AI 1st review comments 3/17/2020

Eldorado Springs at Cheyenne Mountain Filing No. 1

ADMINISTRATIVE SITE DEVELOPMENT PLAN

PRELIMINARY UTILITY PLAN

SHEET SDP11
 WESTWORKS PROJECT # 91807

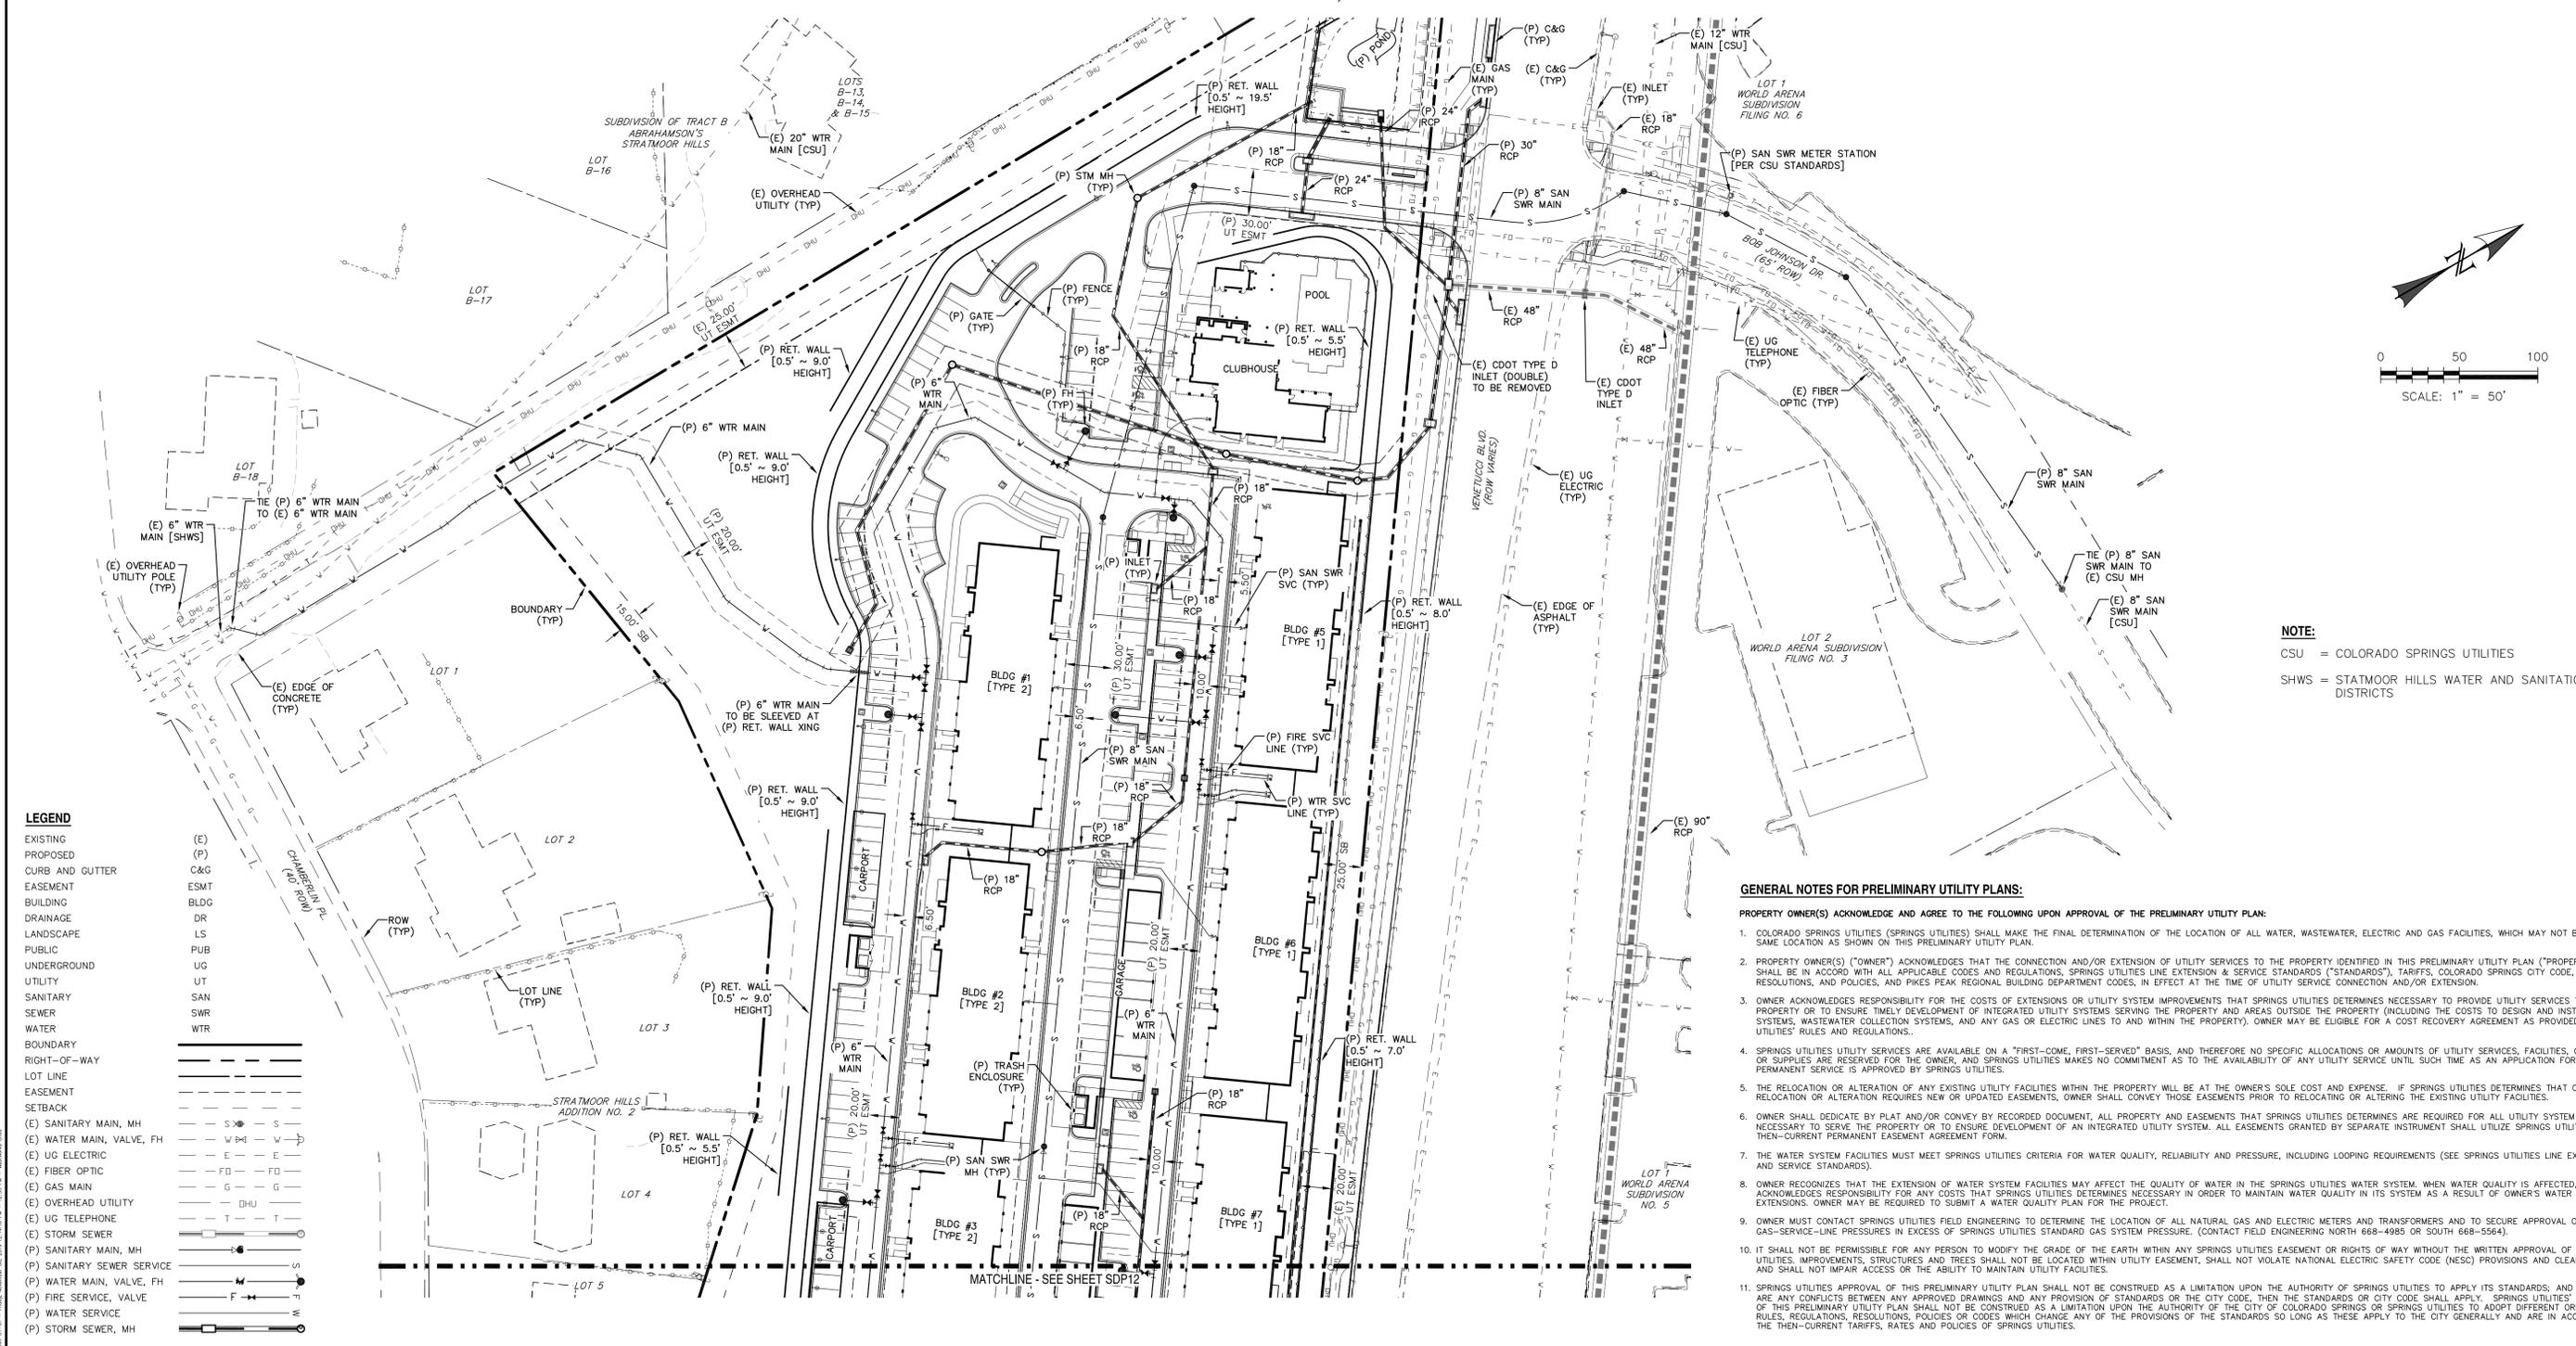
As part of the utility plan please include a the building elevations, and show the location of the gas and electric meters.

Add this note to the utility plan
390,000 and less BTU you need 18-21 inches
390,001-910,000 BTU you need 24-28 inches
* 910,000-1400,000 BTU will need to get approved by CSU Field Services Department for new construction at 719-668-7350 the gas regulator will be required to have 3 dia away from any door or window opening, and no roof is allowed over the gas meter location. Please add this note to the plan set.

Label your plan as a Preliminary
Utility and Public Facilities Plan

Wastewater Master Facility Form
is required for this project.

Label apartments on
your utility plan if this is
what they are.

Show a site map and
vicinity map on utility plan
please.

Does the proposed retaining wall
on the west side of the lot have
GEO GRID if so it can not go
into the 2 foot utility easement
on the west side of the lot.

The wastewater main within
the easement needs to be
private, please remove the
easement for the
wastewater main off of the
drawing.

Label the gas main as 150# if you
will need to maintain 5 vertical
separation between gas and
wastewater crossing.

Dimension the right of
way width in Venetucci
Blvd.

There is an overhead electric line that runs through your site call out a note on what you plan to do with it? as well as the utility easement. Label and call out reception number.

Retaining walls can not be within the public 20 foot utility easement on the east side of the lot.
